Recommendation Report for Planning Permission for Works or Extension to a Dwelling

REF NO: AL/41/26/HH

LOCATION: Karenza
Hook Lane
Aldingbourne
PO20 3TB

PROPOSAL: Single storey side extension, new chimney, roof extension including raising of the ridge height to facilitate conversion of loft to habitable use including 2 No. front dormers and new front canopy.

Proposed South Elevation

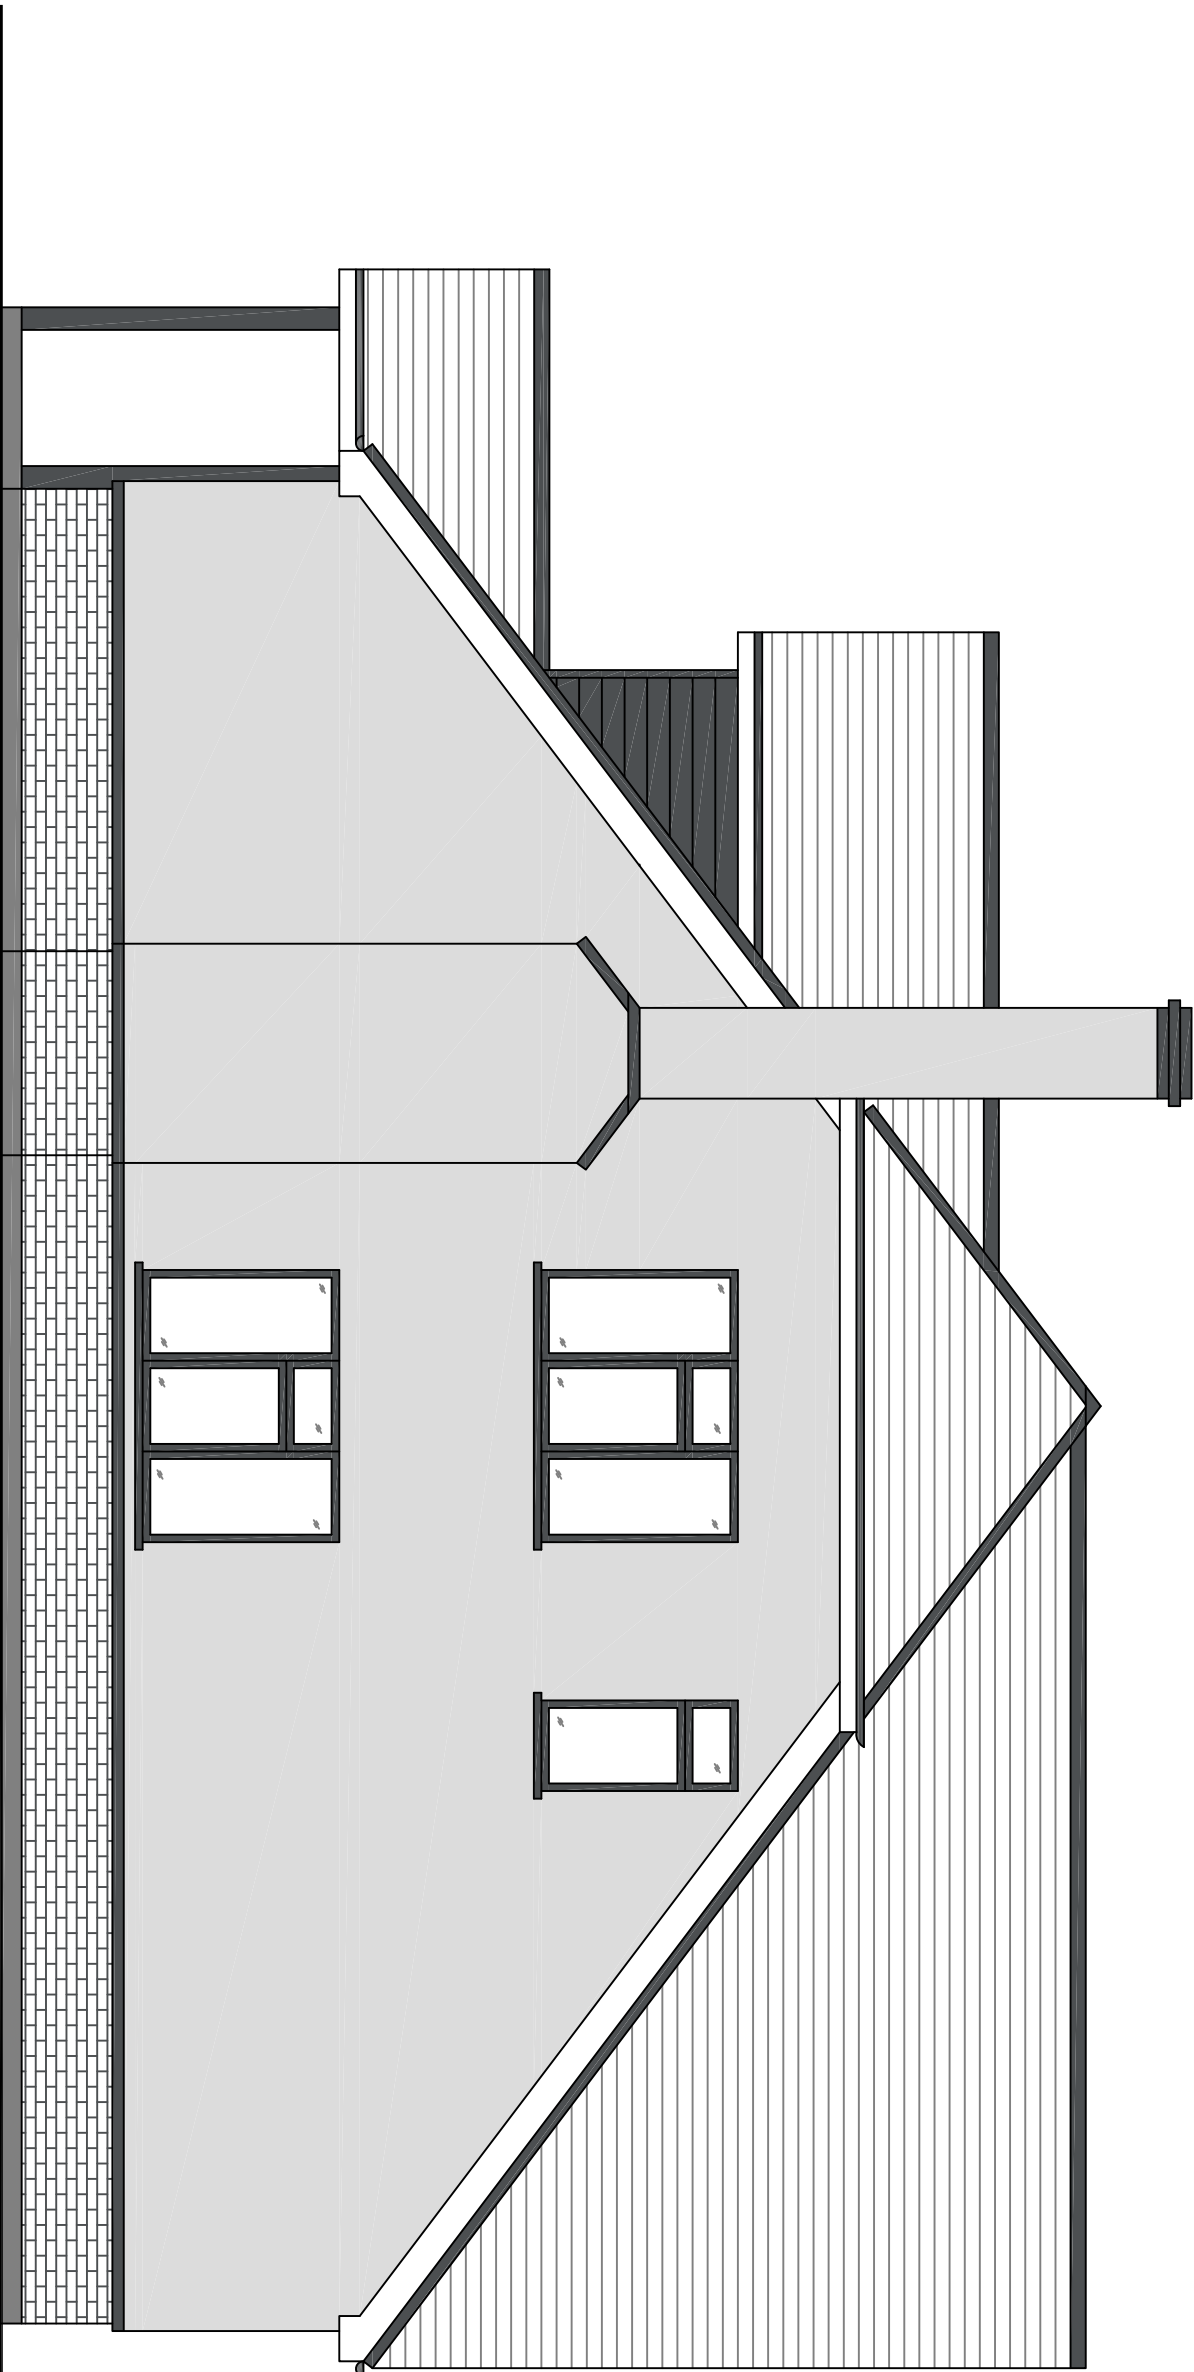
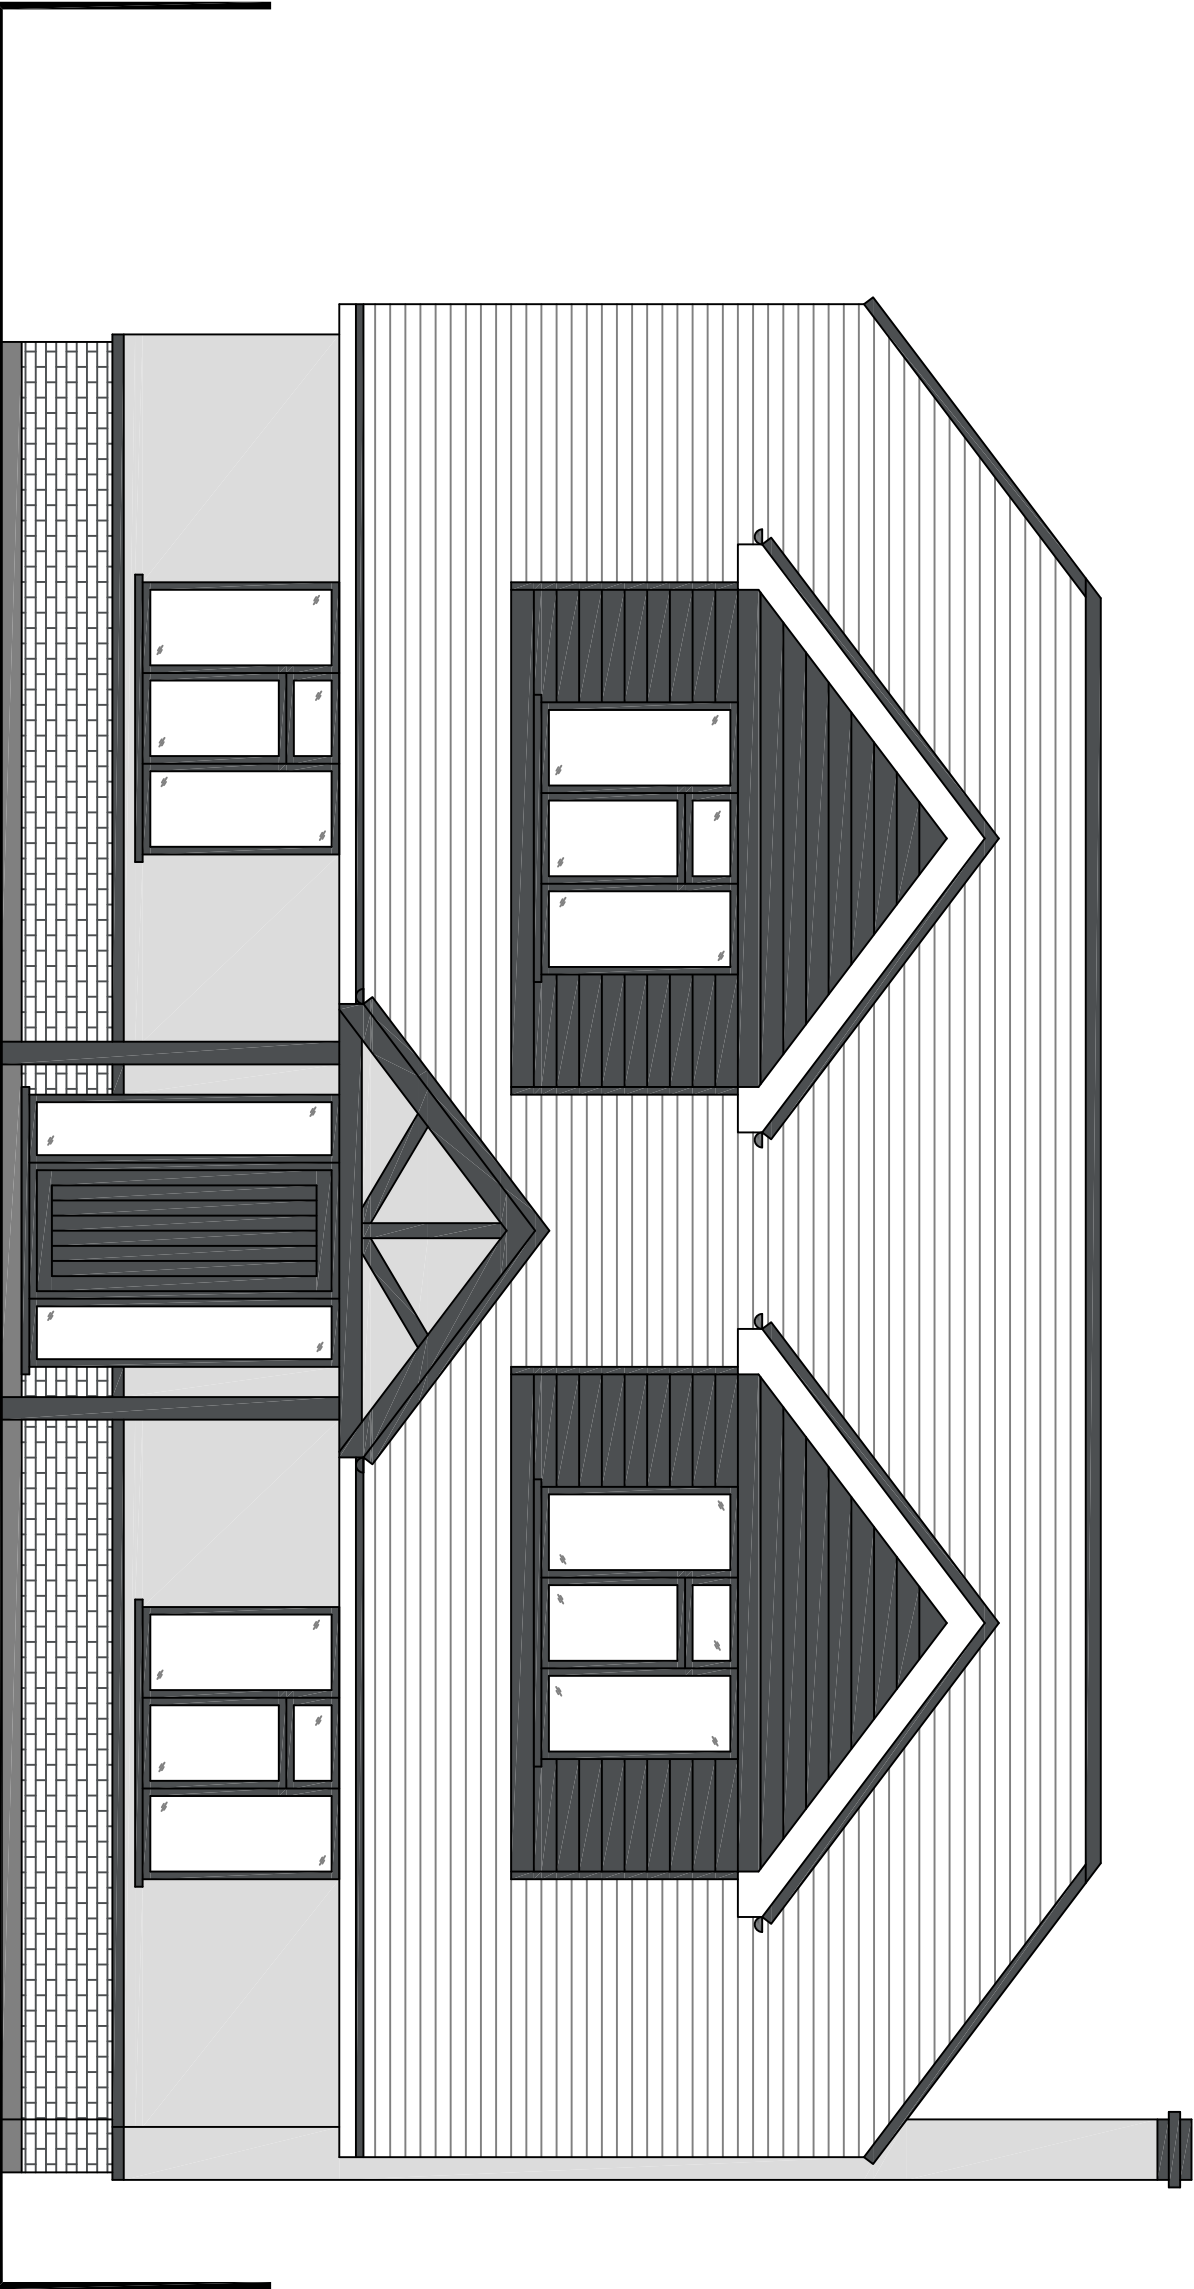
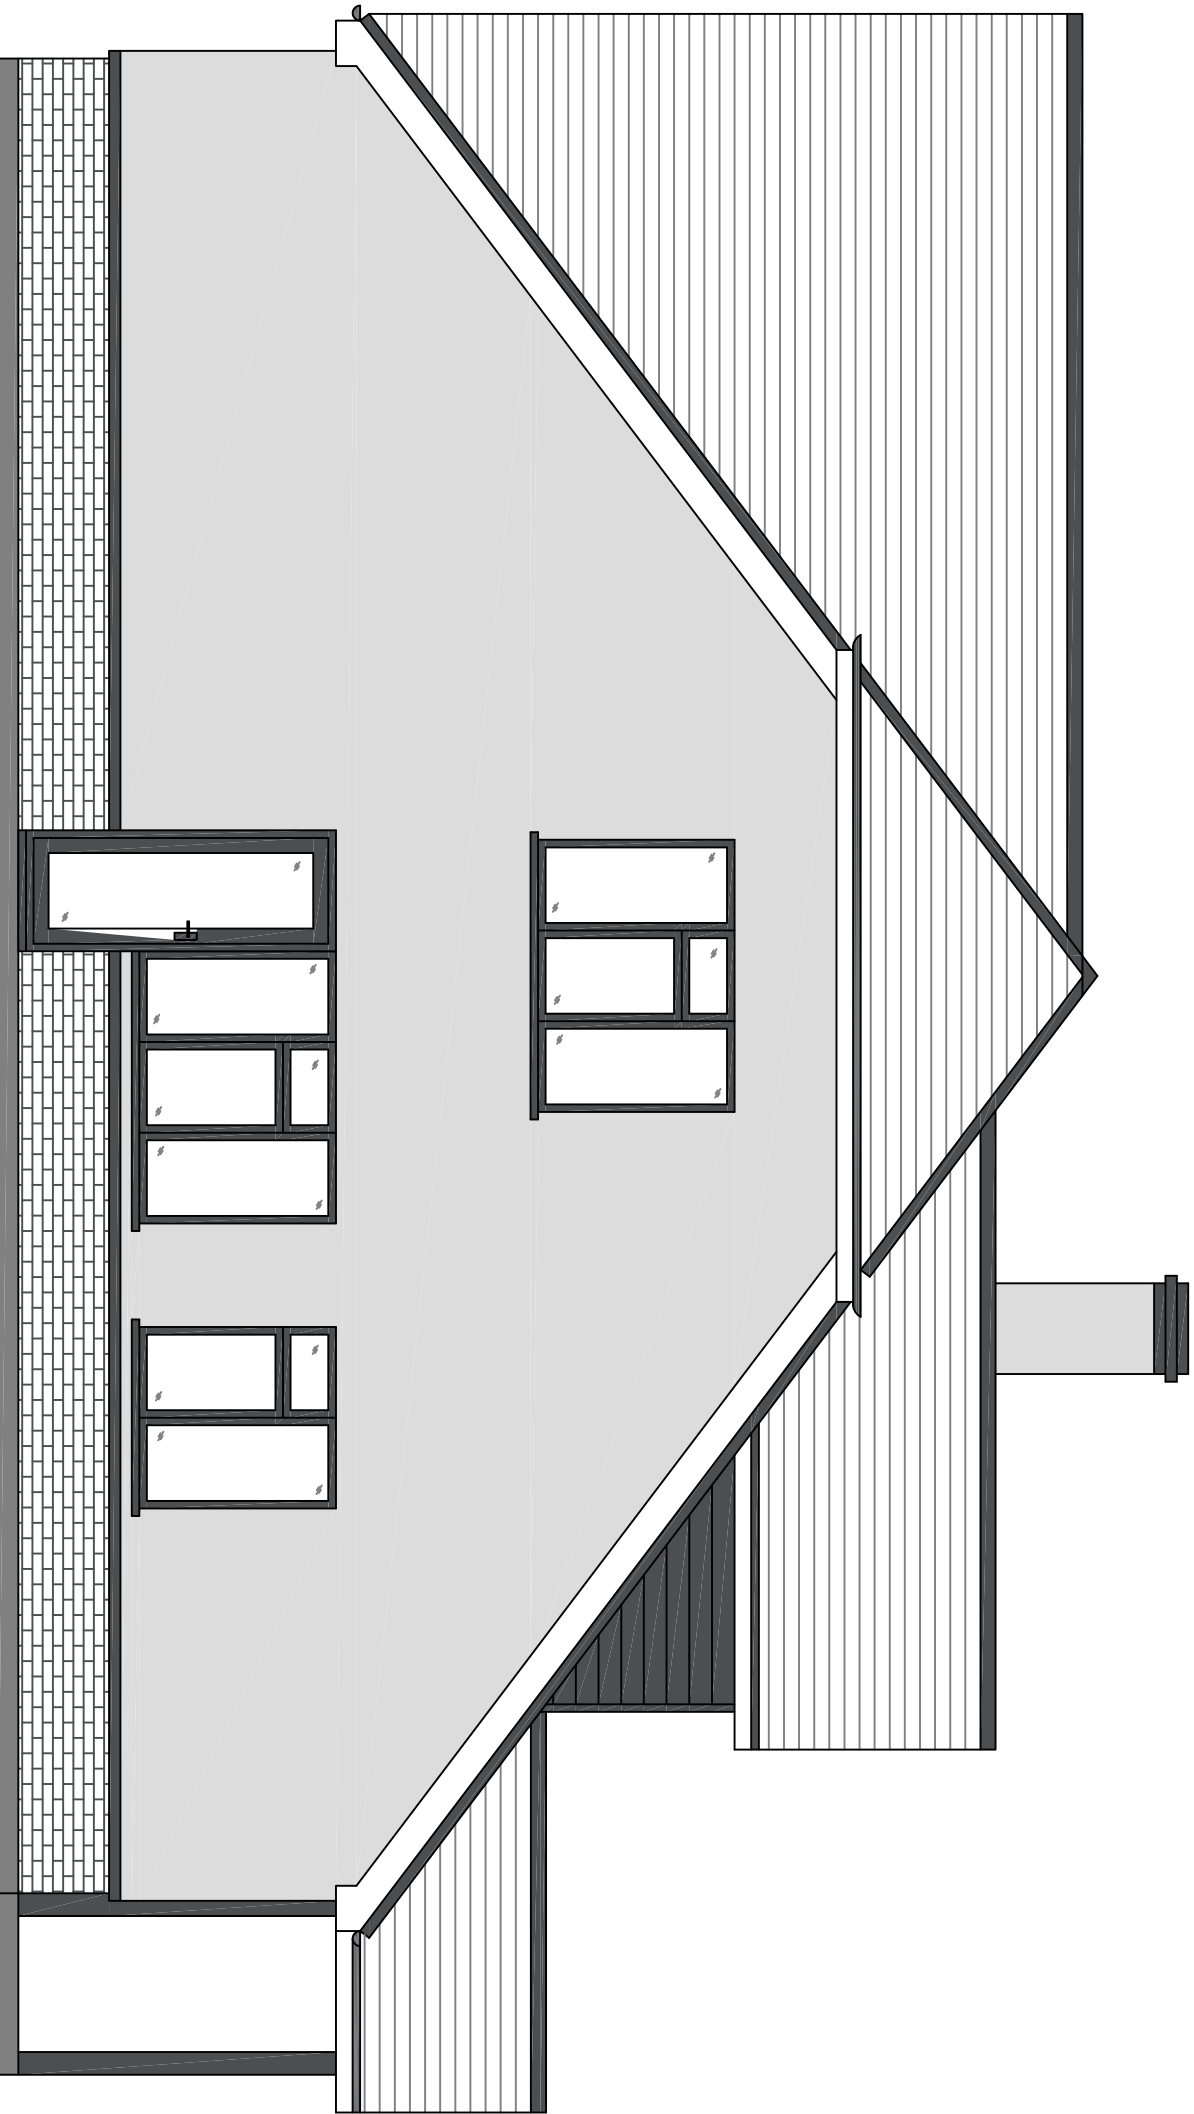
To accommodate a new first floor, it is proposed to raise the roof ridge by 1.7m, to a height of 7.65m. Given the length of the rear garden, the proposal would comply with minimum back-to-back distances of 21m, as described by the ADG. Furthermore, given the existing variation within the wider street scene, the proposed increase in ridge height would not result in harm to visual amenity.

The proposed roof alterations would include the creation of a new rear gable feature, which would span the width of the dwelling following the side extension and be equal in height to the new ridge line. The new roof slopes would slope towards the centre of the dwelling to the front and rear as the ridge line would run from west to east rather than from north to south as existing. The clipped side gables would help reduce the overall bulk following the substantial increase in roof form. Given the existing variation within the wider locality and street scene with regards to roof forms, the proposed alterations to the roof would not result in harm to visual amenity, albeit an increase in bulk and massing of the dwelling.

The new rear gable would include extensive glazing, with the new windows spanning across the whole first floor level, resulting in a contemporary, modern appearance. The locality is not characterised by modern design; there is a distinct rural character. Notwithstanding this, given the siting of the modern gable at the rear of the site, equal in depth to the existing rear wall and 38m from the rear boundary, there would be no undue harm to design or visual amenity.

The ADG advises that dormers should be located symmetrically on the roof slope, avoid flat roof form and be sited away from hips and ridges; The two front dormers proposed would have pitched roof slopes, be set in from the flank elevations by 1.9m and would be set down from the new roof ridge by 0.7m, therefore compliant with ADG standards.

The proposed front porch canopy would project 1.3m beyond the front building line and would have a pitched roof, compliant with ADG guidance for porch / front extensions. Set centrally on the front elevation, between and below the two dormers, the front canopy would be a sympathetic addition.
